Appeal Decision

Appeal Ref: APP/R5510/W/22/3301303

Nursery, Lawn Road, Uxbridge UB8 2TJ

- The appeal is made under section 78 of the Town and Country Planning Act 1990 against a failure to give notice within the prescribed period of a decision on an application for planning permission
 - The appeal is made by RBMF Developers Ltd against London Borough of Hillingdon.
 - The application Ref 75251/APP/2021/4446, is dated 6 December 2021.
 - The development proposed is Redevelopment/refurbishment of nursery building (Use class E) including demolition of annex and rear extension. Erection of a three storey building comprising 1 x 1 bed, 1 x 2 bed residential units (Use class C3).
-

Drawing
Proposed FFP

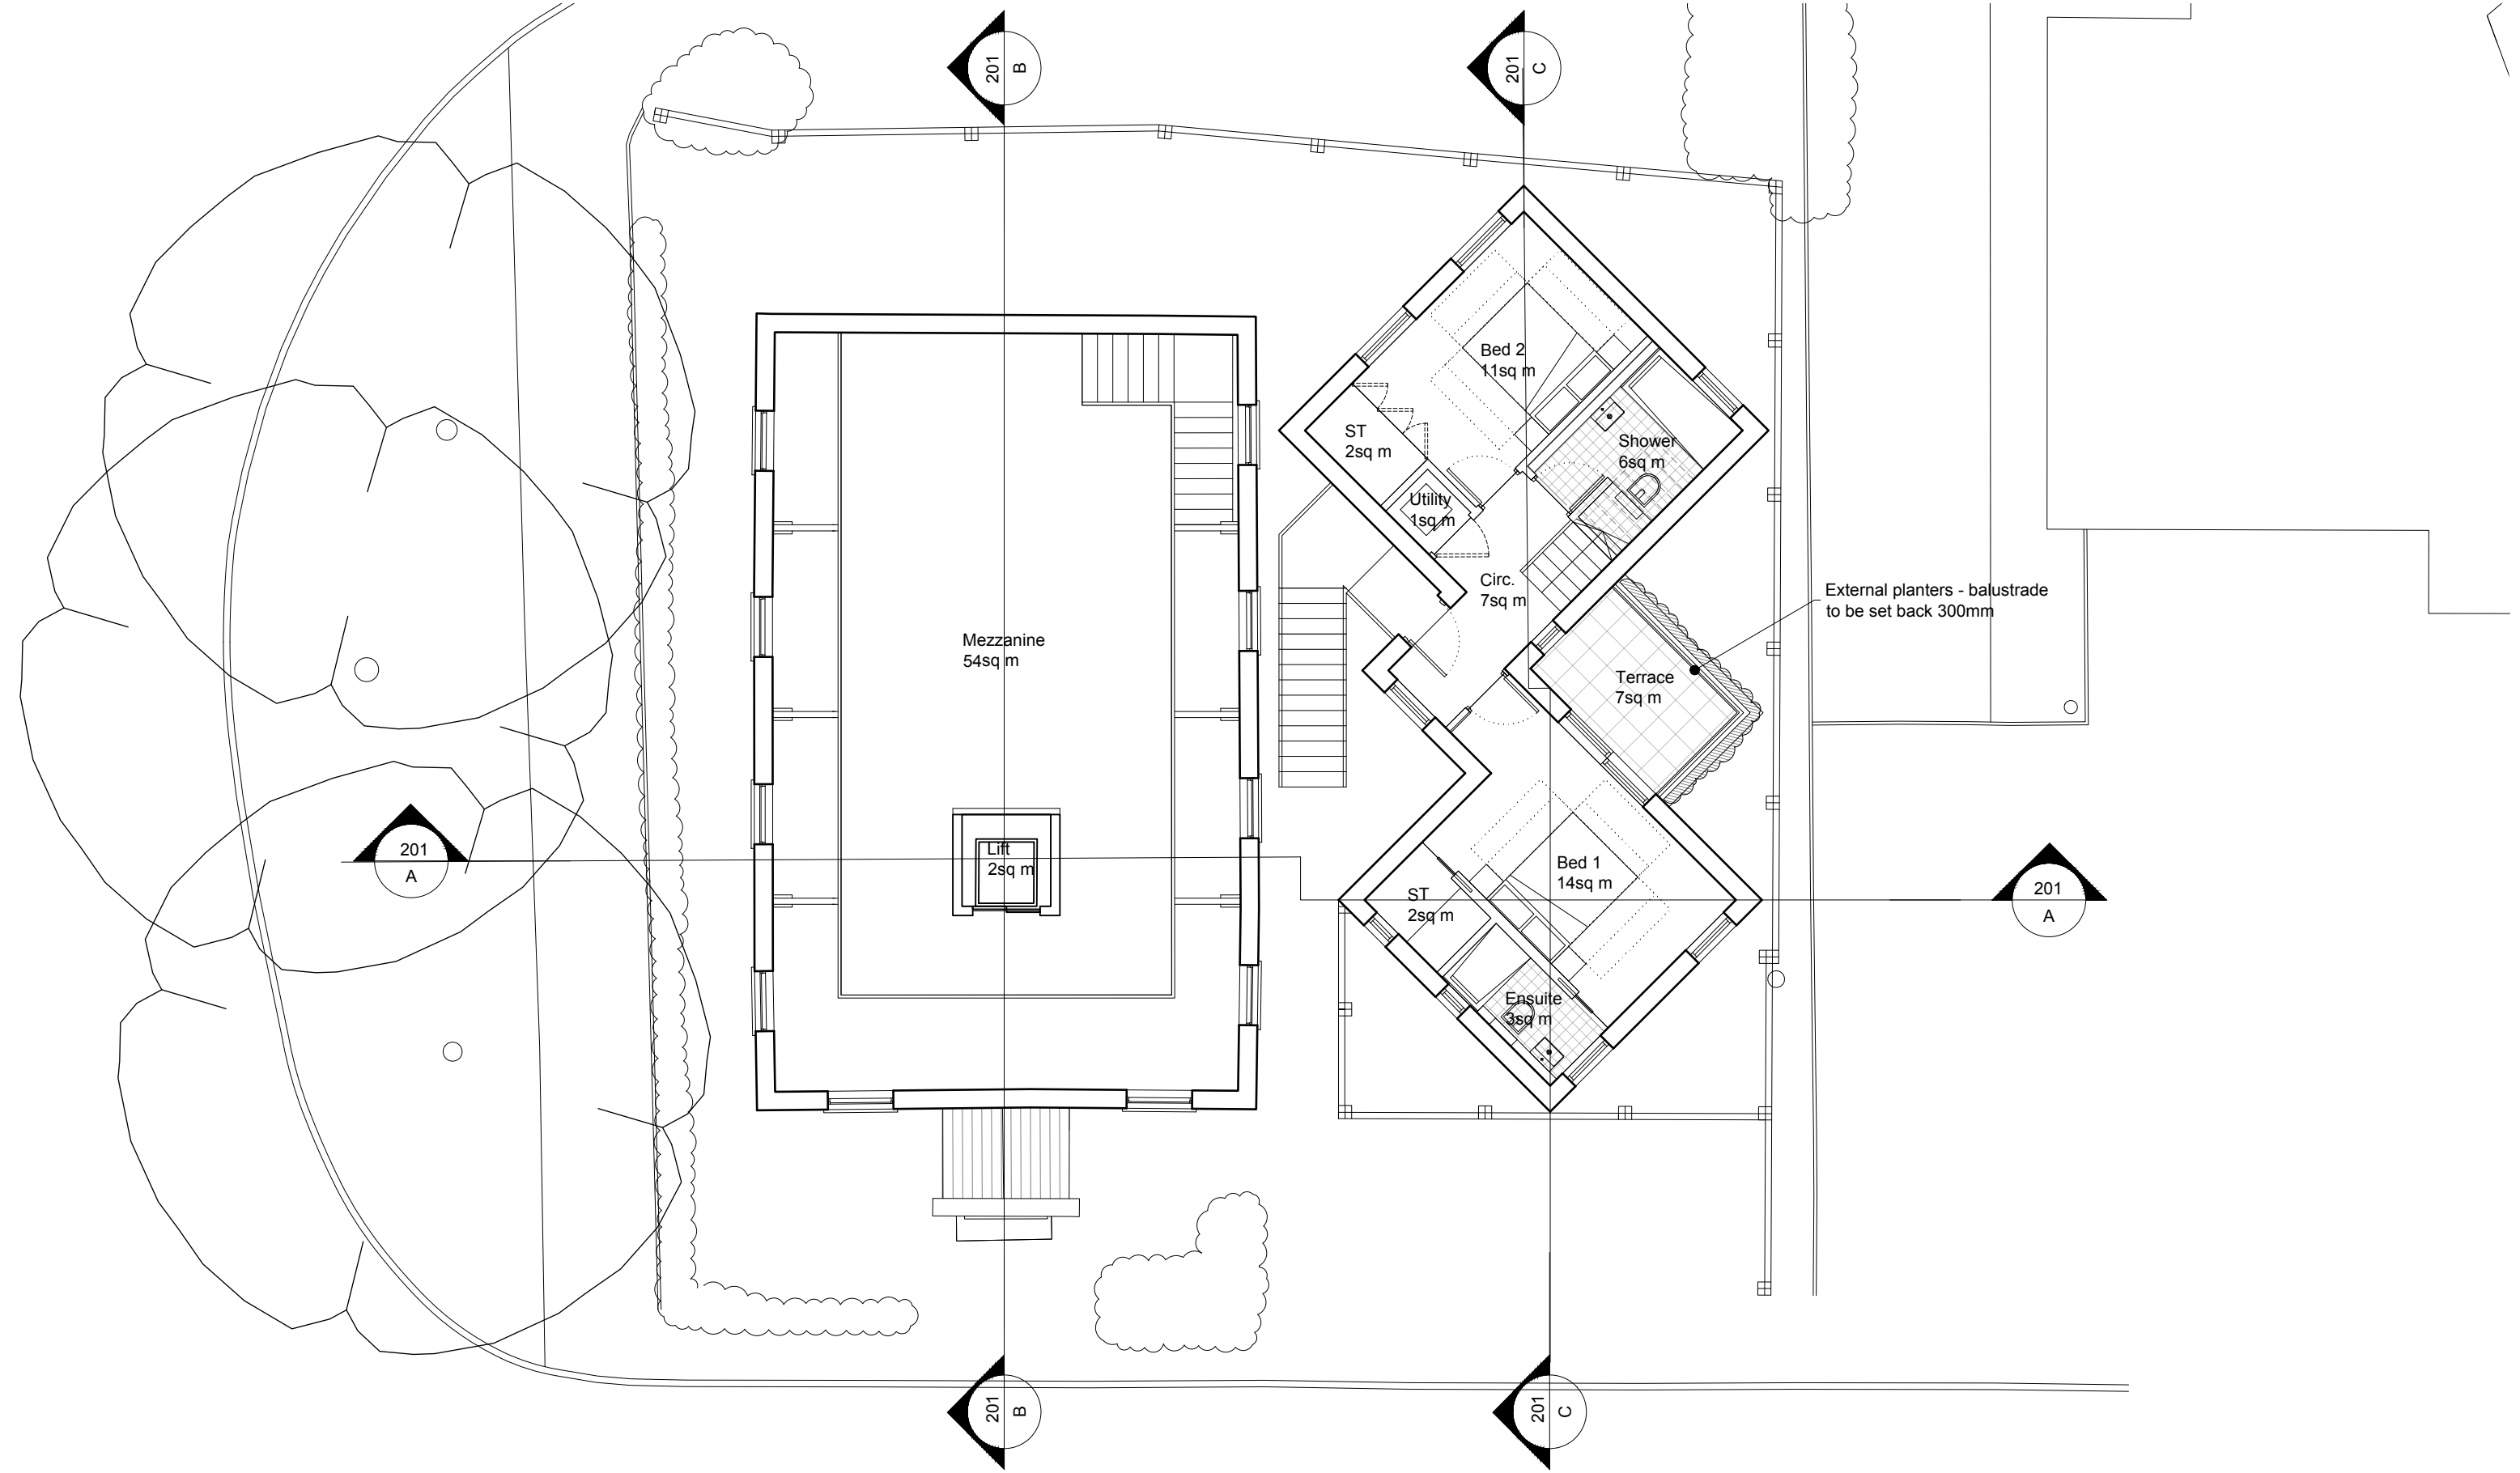
18. The first floor bedroom windows and the second floor living room windows within the proposed building would face directly toward the external play area of the Nursery. Given the elevated nature and close proximity, this would result in a significant level of overlooking. The appellant indicates that these windows would be obscure glazed, which would preclude views. This could be conditioned were I minded to allow the appeal.

1 North Elevation

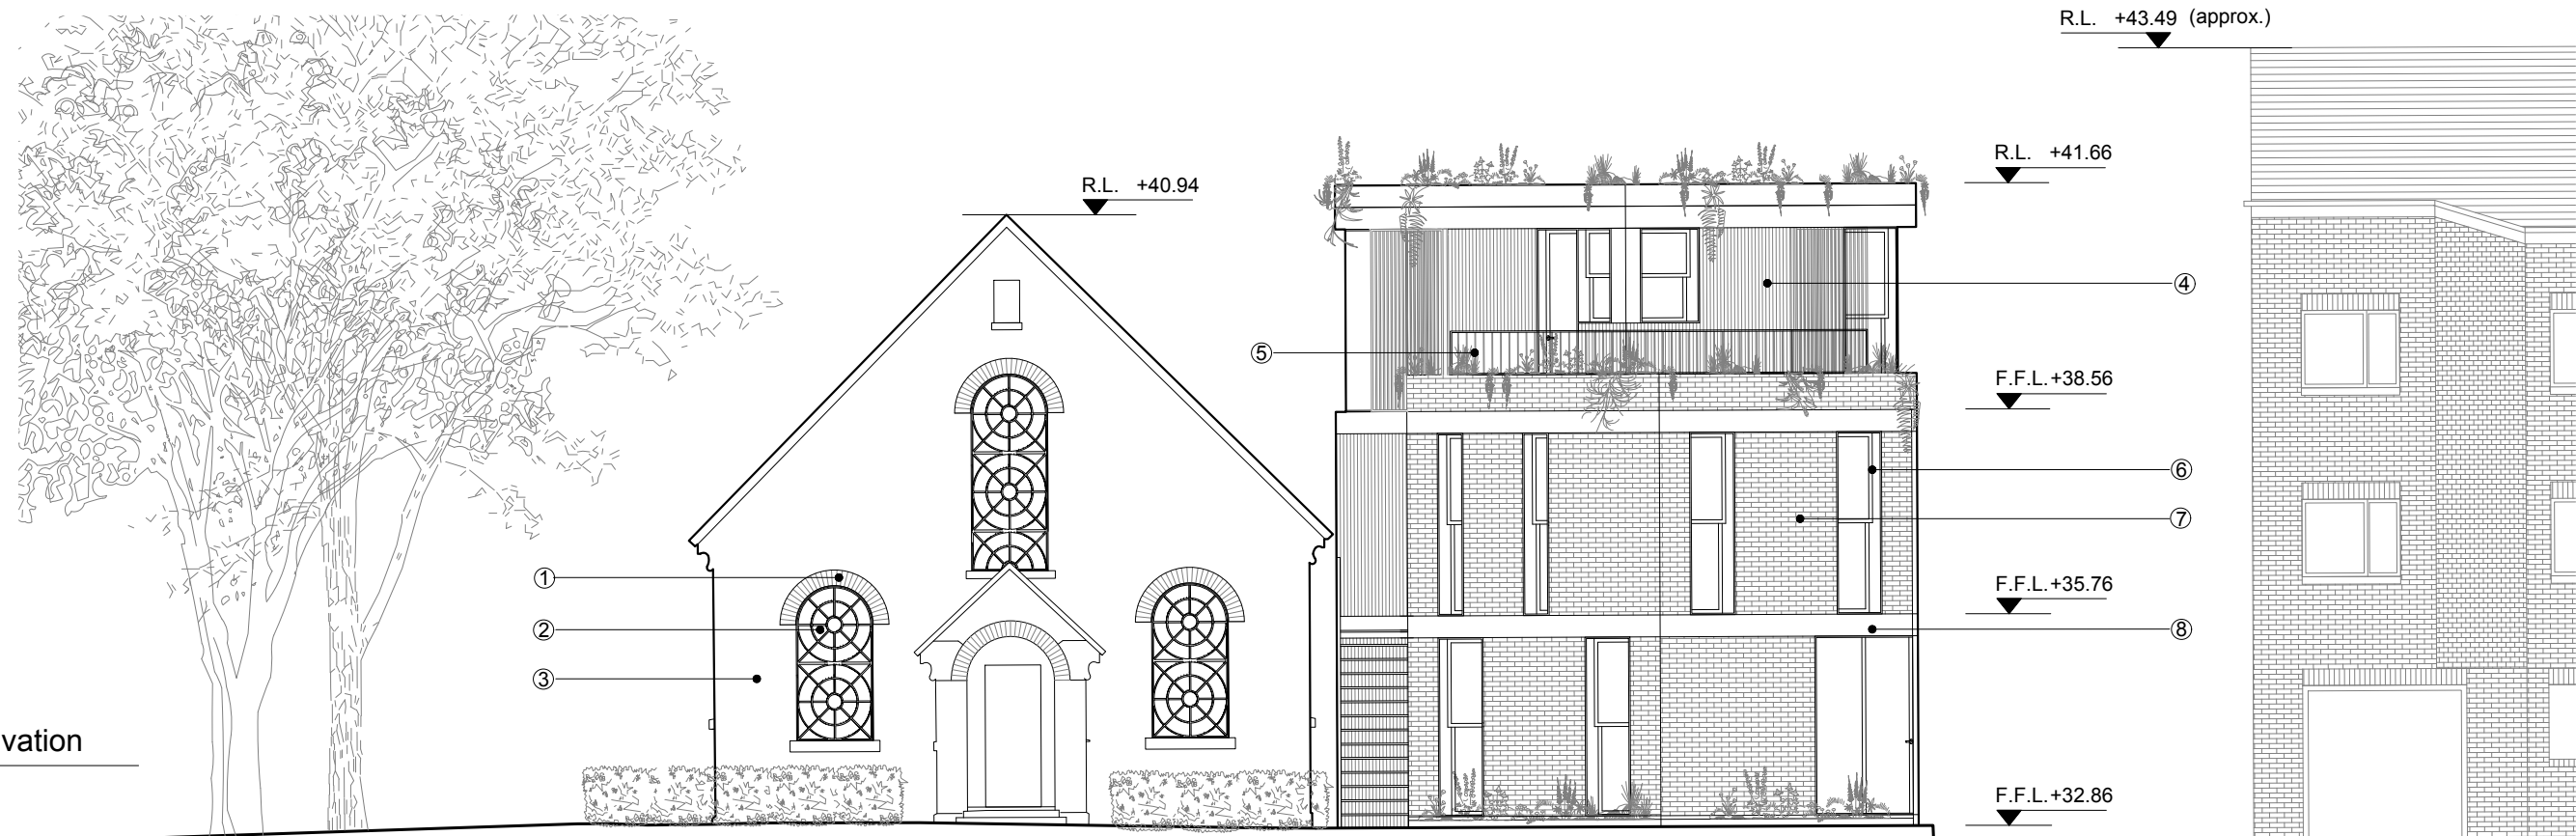
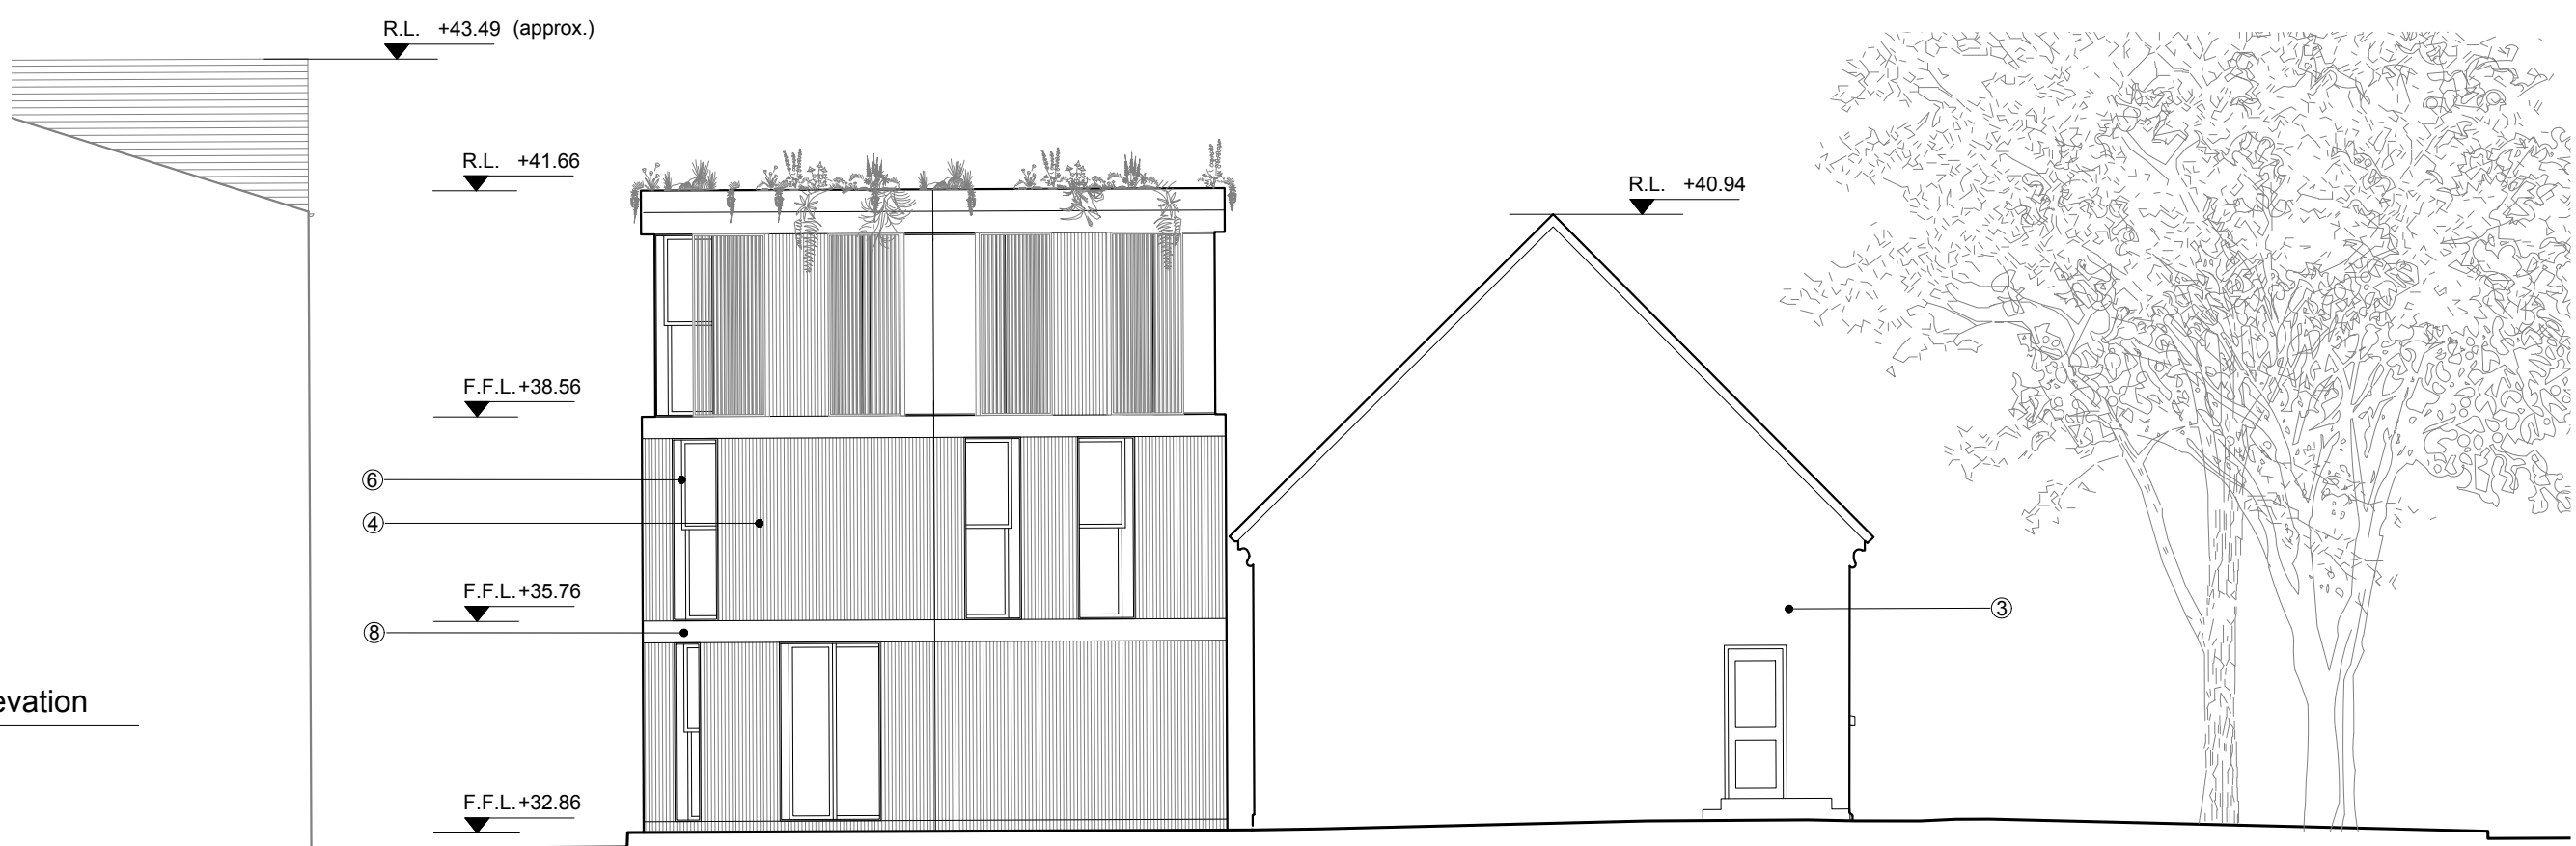
9. The contemporary design with its angular form to Lawns Road, use of fibre cement board, prominent roof terrace and flat roof would exacerbate the effects from the scale and positioning, combining to jar injuriously in this location, against the simplicity, modest form, and proportions of the Chapel. This would also undermine the prominence of the Chapel, and thus, its historical and communal importance. There maybe flexibility with some elements, such as the fibre cement board, but that would not overcome my overall concerns.

10. The proposed building would be lower than the large block of flats and, in this regard, the built form would step down to the Chapel. However, there would be a larger gap to the block of flats than there would be to the Chapel, and the proposal would be set forward from the flats, increasing the proposed development's prominence in the street scene. As such, the lower height in relation to the flats does not overcome my concerns regarding the height and physical relationship with the Chapel.
